2 Environmental Statement (ES) [APP-029 to APP-208]

The Proposed Scheme - ES Chapter 2 [APP-030]

Project Title		M20 JUNCTION 10A			
Drawing Title		RIGHTS OF WAY AND ACCESS PLANS			
Drawing Status		DCO SUBMISSION (TR010006)			
Scale		1:1250			
Original Size	Date	Designed	Drawn	Checked	Authorised
A1	JULY 16	RD	RD	FT	HNK
Drawing Number		HA514442-MMGLV-GEN-SMW-DE-Z-2403			
Revision		B

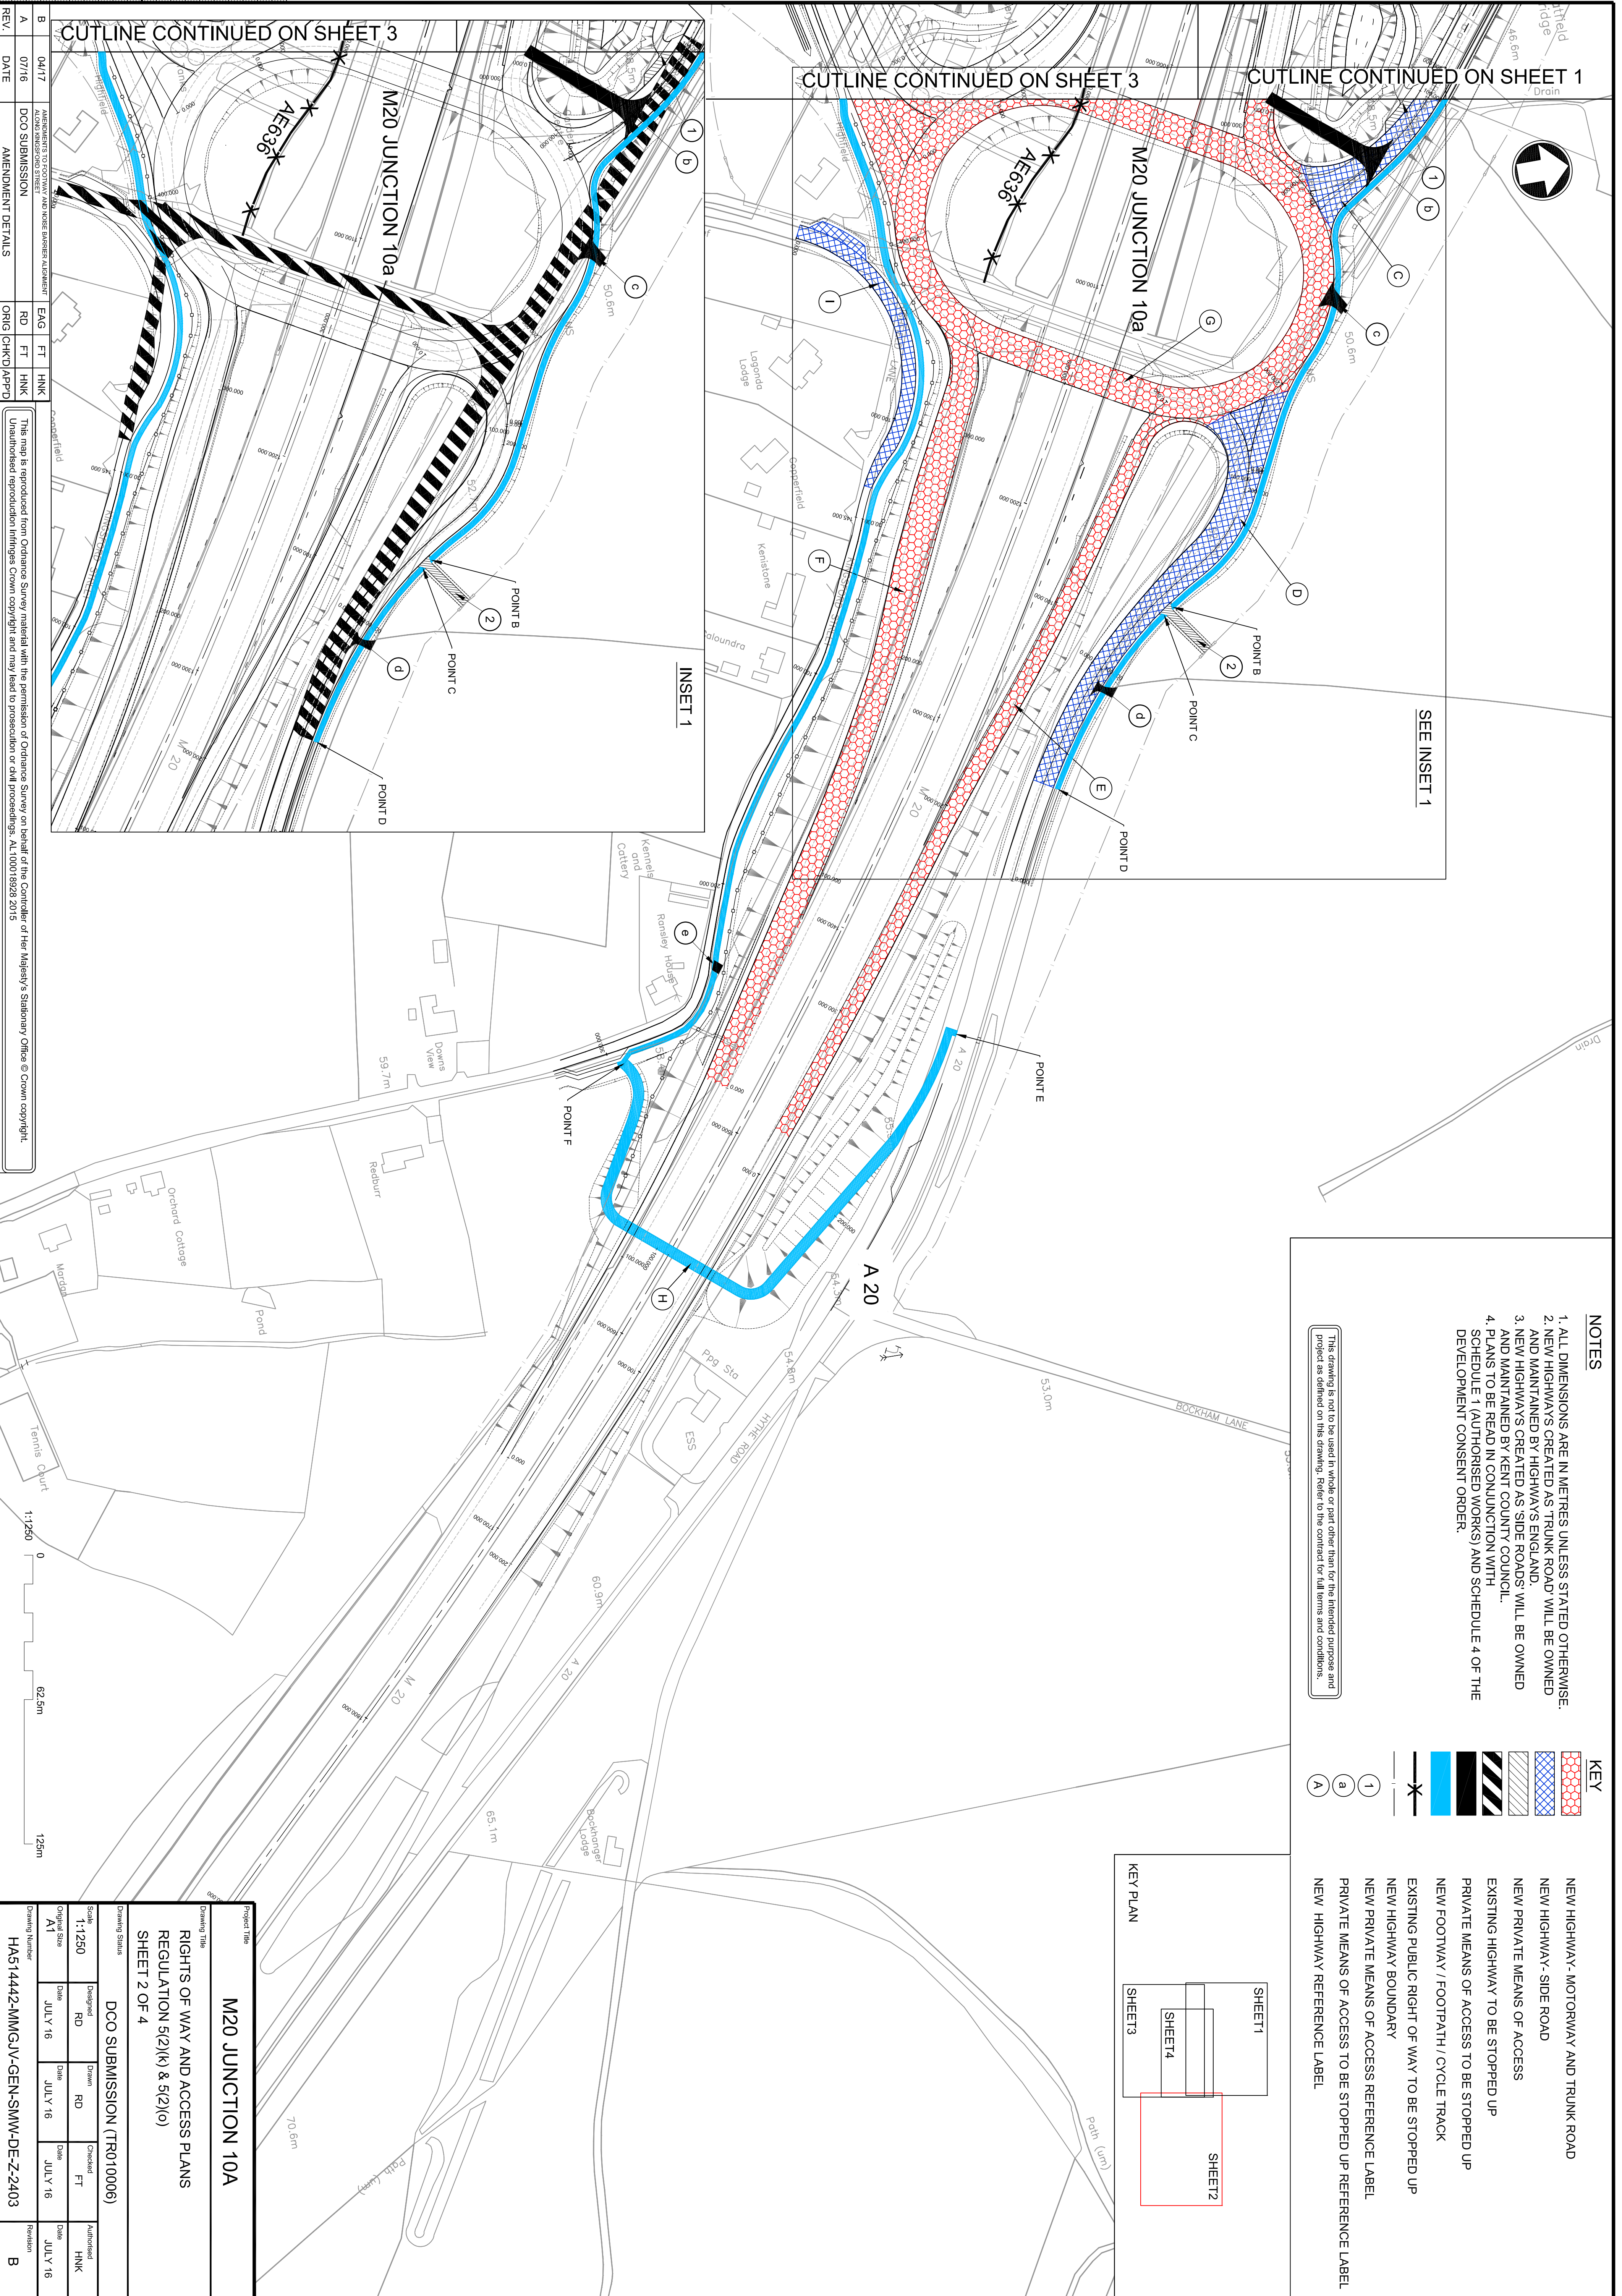
2.04	Applicant; KCC	<p>Public Rights of Way (PRoW)</p> <p>Re. KCC’s submission at Deadline 5 [REP5-026]:</p> <ul style="list-style-type: none"> i. Would the Applicant and KCC state whether they have reached agreement on the level difference between the PRoW and the alignment of the A2070?
------	----------------	---

During the open floor Hearing, a request was made from the British Horse Society that provision be made for safe access on to and across the A20 Hythe Lane from the new Kingsford Street Bridge, linking to both the A20 and Bockham Lane. KCC supports this request. Equestrians and non-motorized users (NMUs) are to be accommodated as part of the bridge construction; provision is therefore required to ensure continuity of the route. This road is subject to a 60mph speed limit and when heading north west, this combines with a left hand bend, so consideration should be given to extending the requested 40mph limit to a suitable point.

The detailed design leads have confirmed that they are aware of the issue around the level difference and that it will be factored into their process. KCC is therefore confident that the level difference is being addressed as part of the detailed design process and the HE’s design team will discuss with KCC Asset Managers.
